05 June 2015

Objection Against Application PO/3/15/HH - Proposed Extension to 3 Arundel Road, Poling

PROPOSED FRONT ELEVATION
North

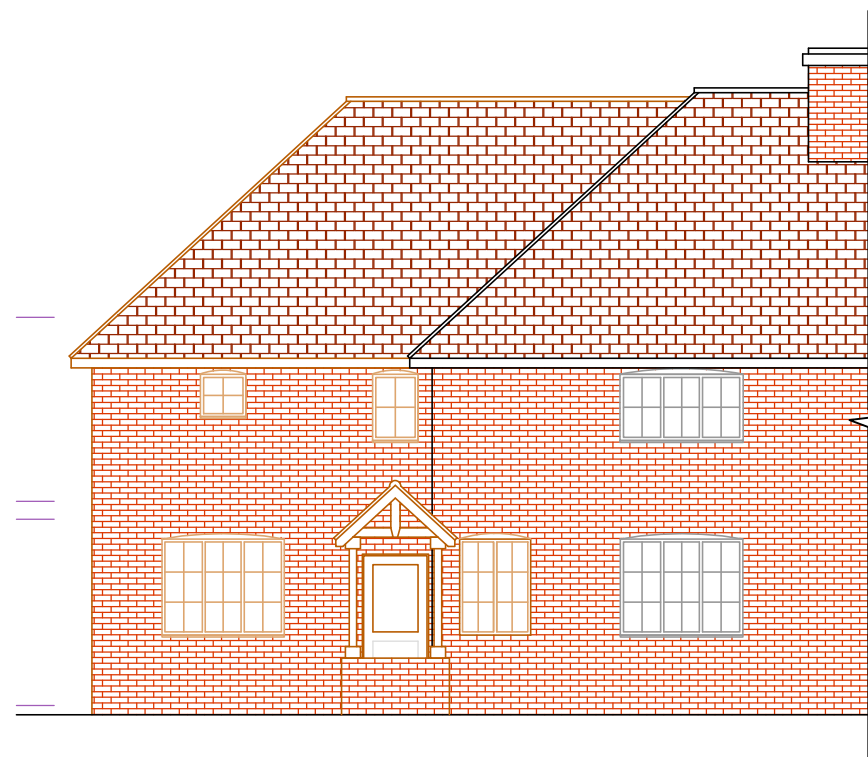
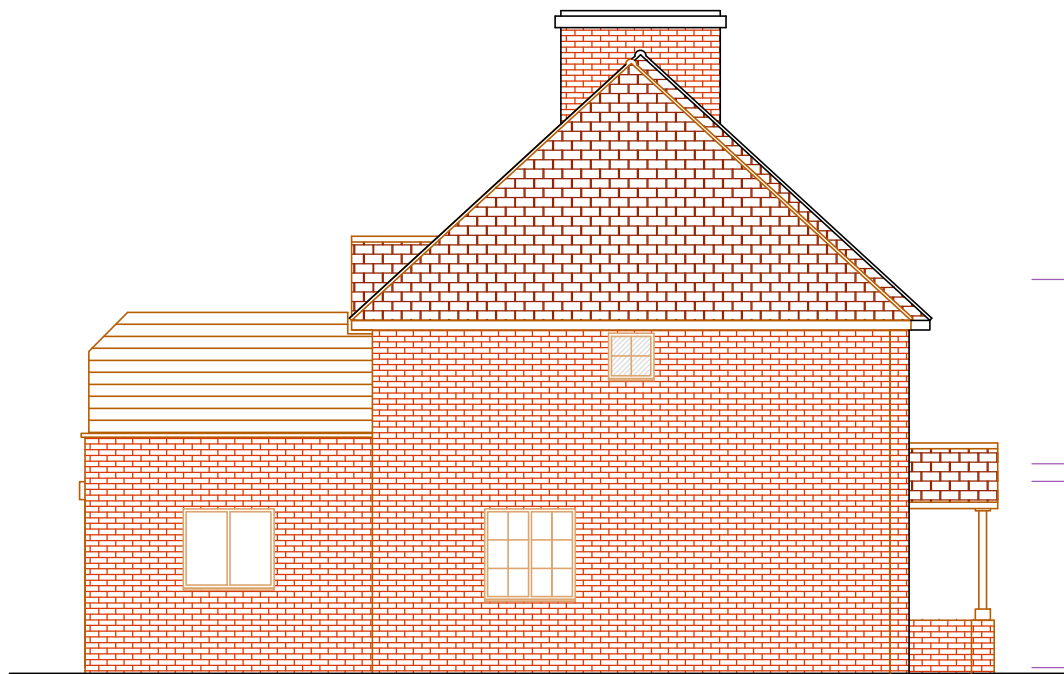
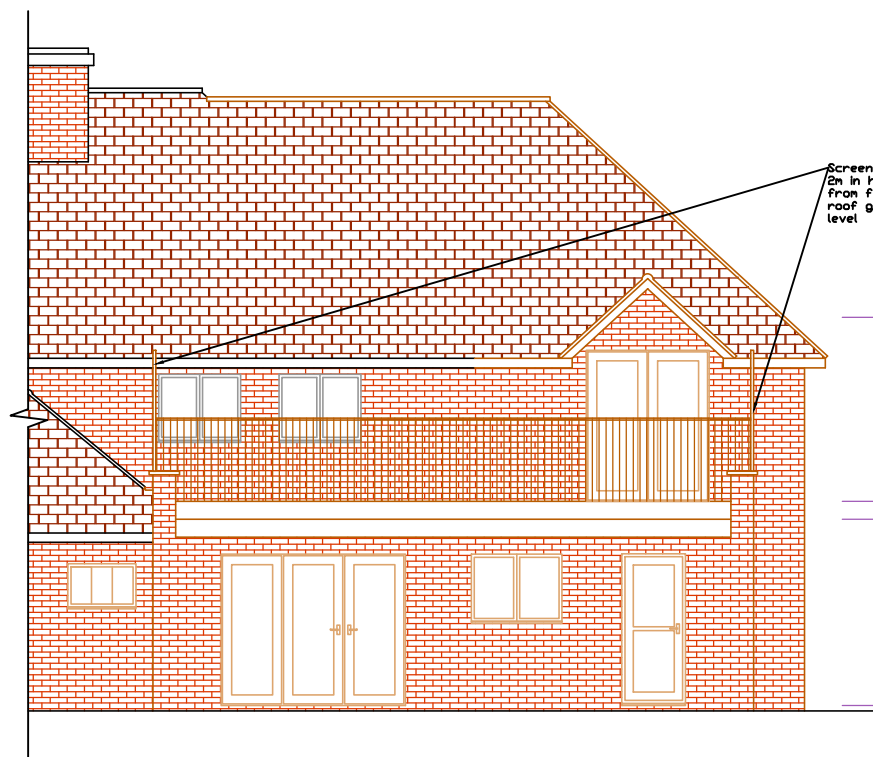
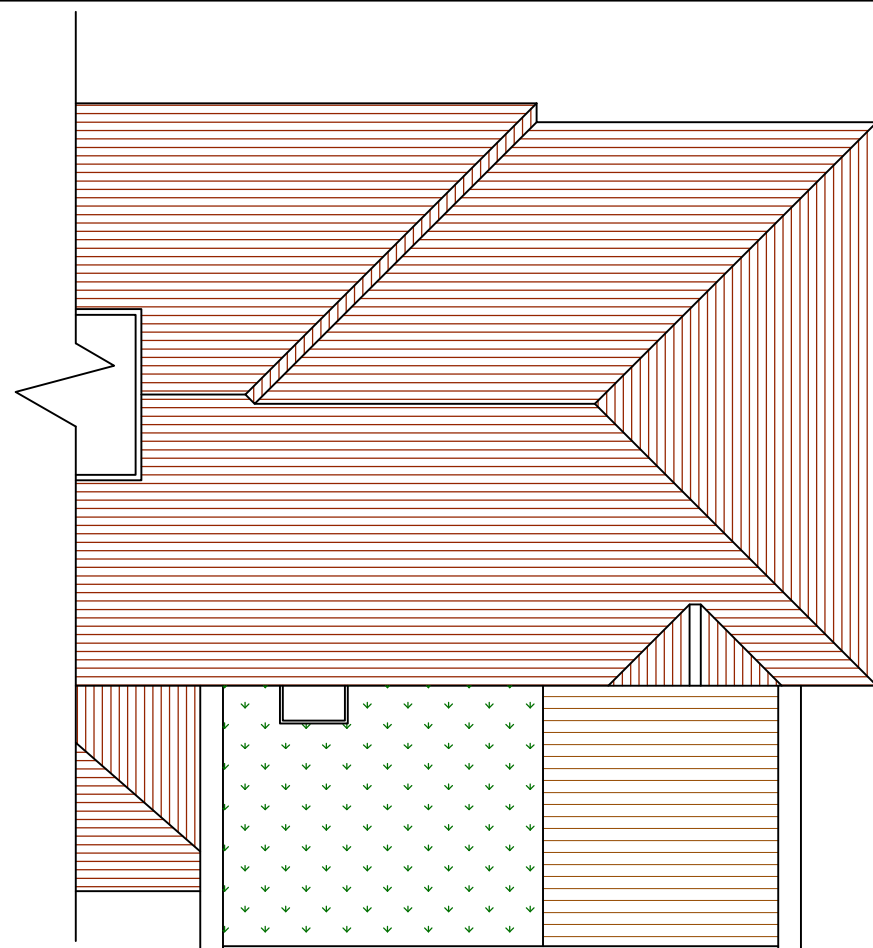
1. The application is very similar to application ref: PO/4/14/HH which was refused by your council on 10th April 2015. Although it is acknowledged that the width of the proposed extension is slightly less than in the original proposal, it is still believed that the height, size and design of the proposed two storey side extension would not be subservient to the main dwelling and would result in an unbalanced appearance to the pair of properties and would be visually obtrusive and out of keeping in the street scene contrary to policies GEN7 (no illustrated written analysis of the site and its immediate setting, etc has been submitted) and DEV19 (i), (ii) and (v) of the Arun District Local Plan 2003, to policies D SP1, D DM1 and D DM4 (a), (b) & (e) of the Publication Version of the Arun District Local Plan 2011-2031 and the NPPF.

PROPOSED REAR ELEVATION
South

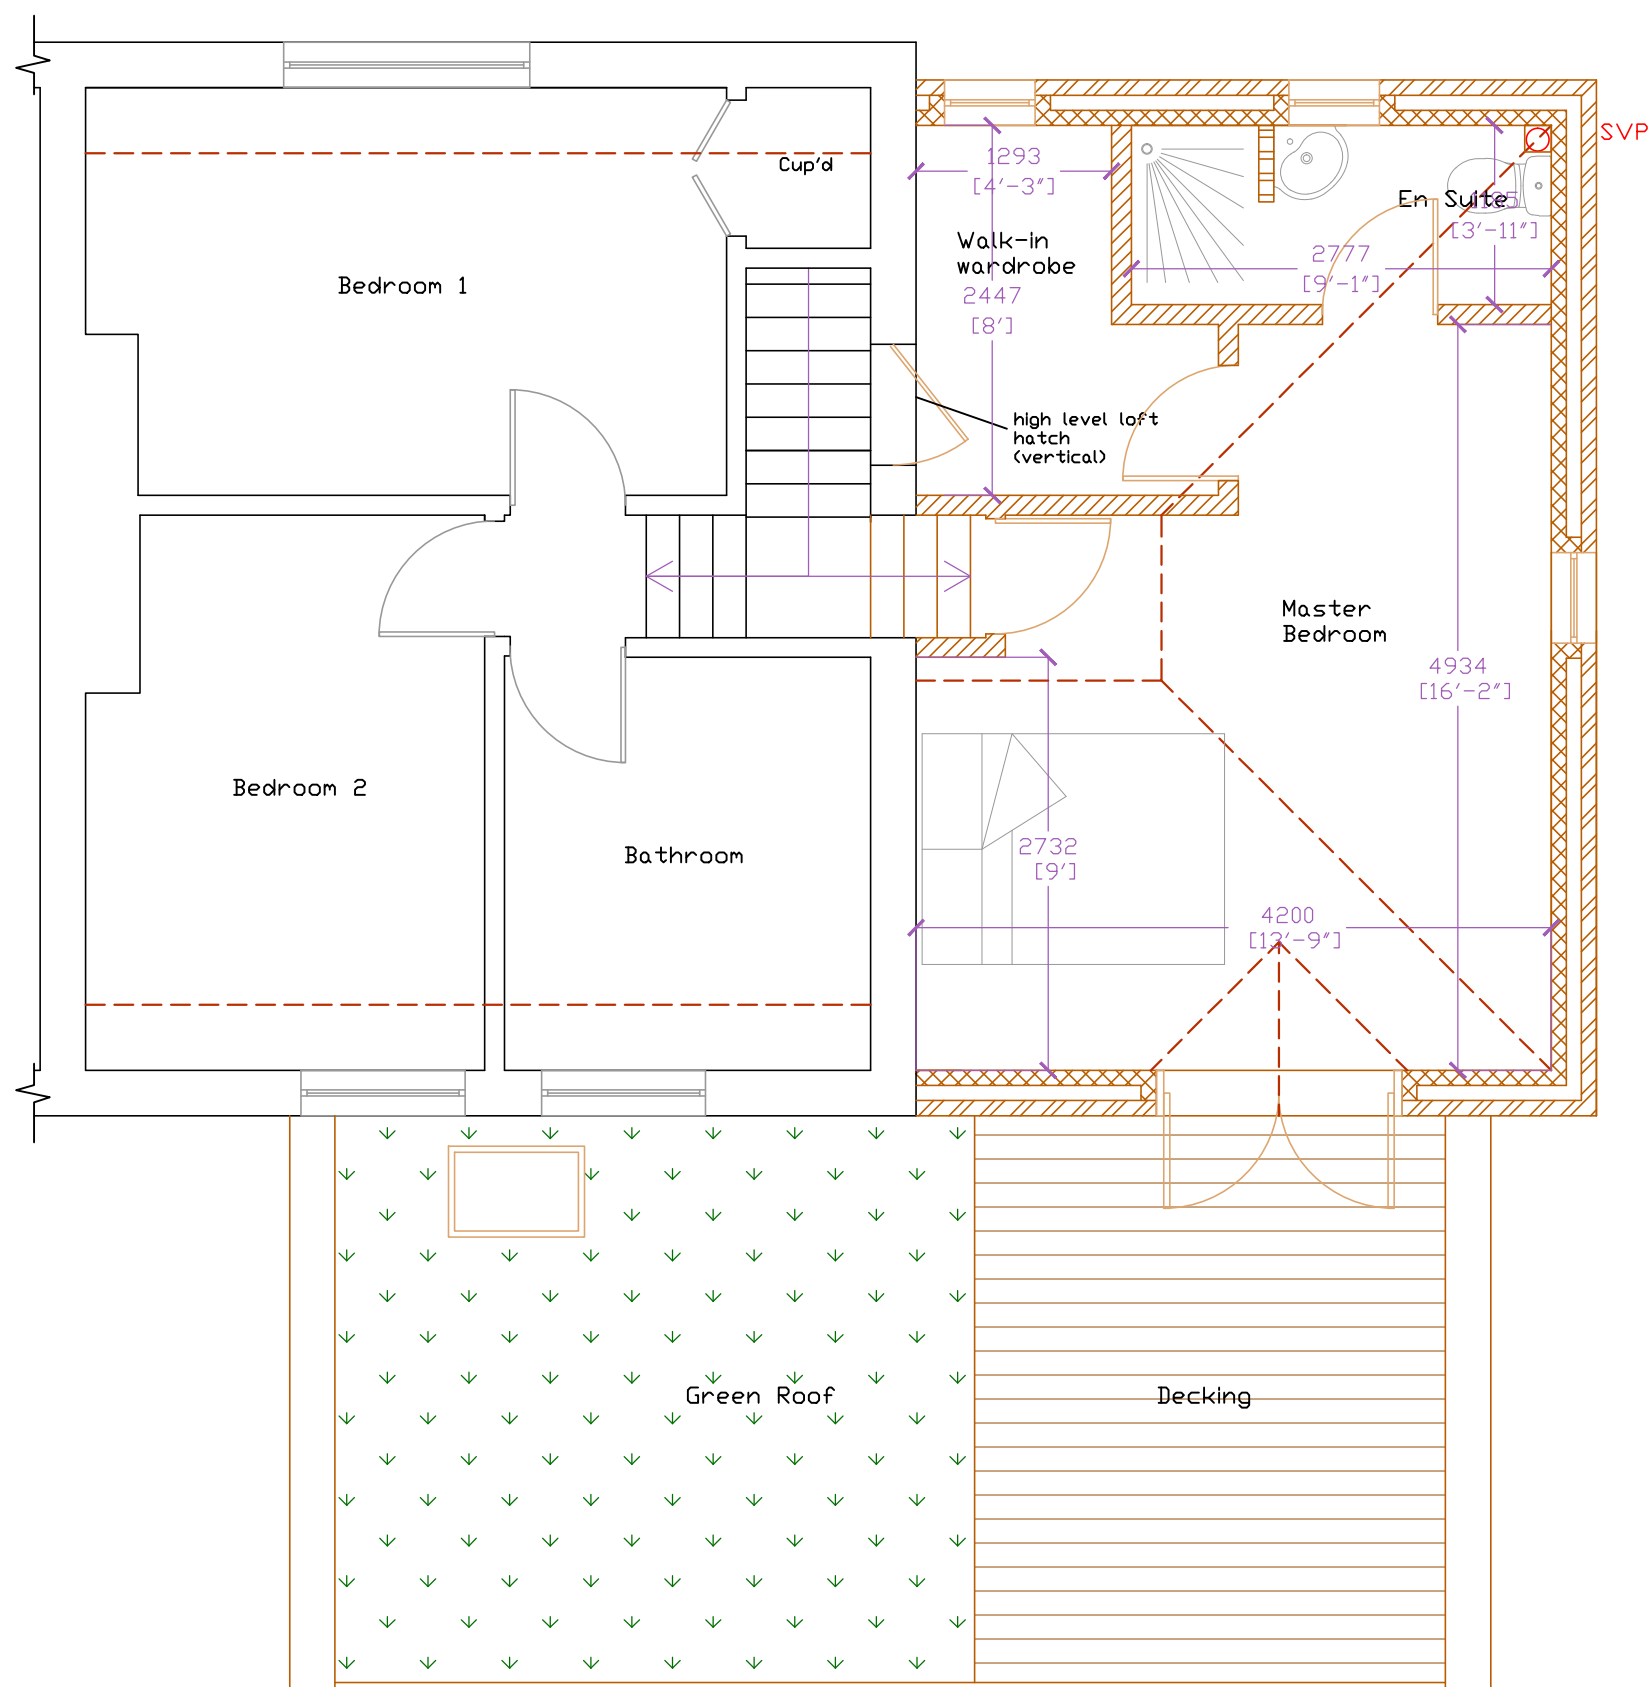
2. The proposed balcony, accessed via casement doors from the new master bedroom, will lead to unacceptable overlooking of my client's rear garden leading to a significant loss of privacy. Furthermore, if permitted, there would be no reason why the area of decking could not, subsequently, be extended onto all or part of the proposed "green roof" leading to a further amplification of such overlooking and intrusion of privacy. The degree of overlooking from use of the balcony, as compared to the potential for overlooking from a normal window in the same position within the master bedroom, would be substantially greater and more oppressive. People tend to stand and look out of a bedroom window for a brief moment, whereas they deliberately sit and socialise with family and friends for extended periods of time on a balcony. This element of the proposal would be contrary to policies DEV19 (iii) of the Arun District Local Plan 2003, to policies D DM1 (3) and D DM4 (c) of the Publication Version of the Arun District Local Plan 2011-2031 and the NPPF.
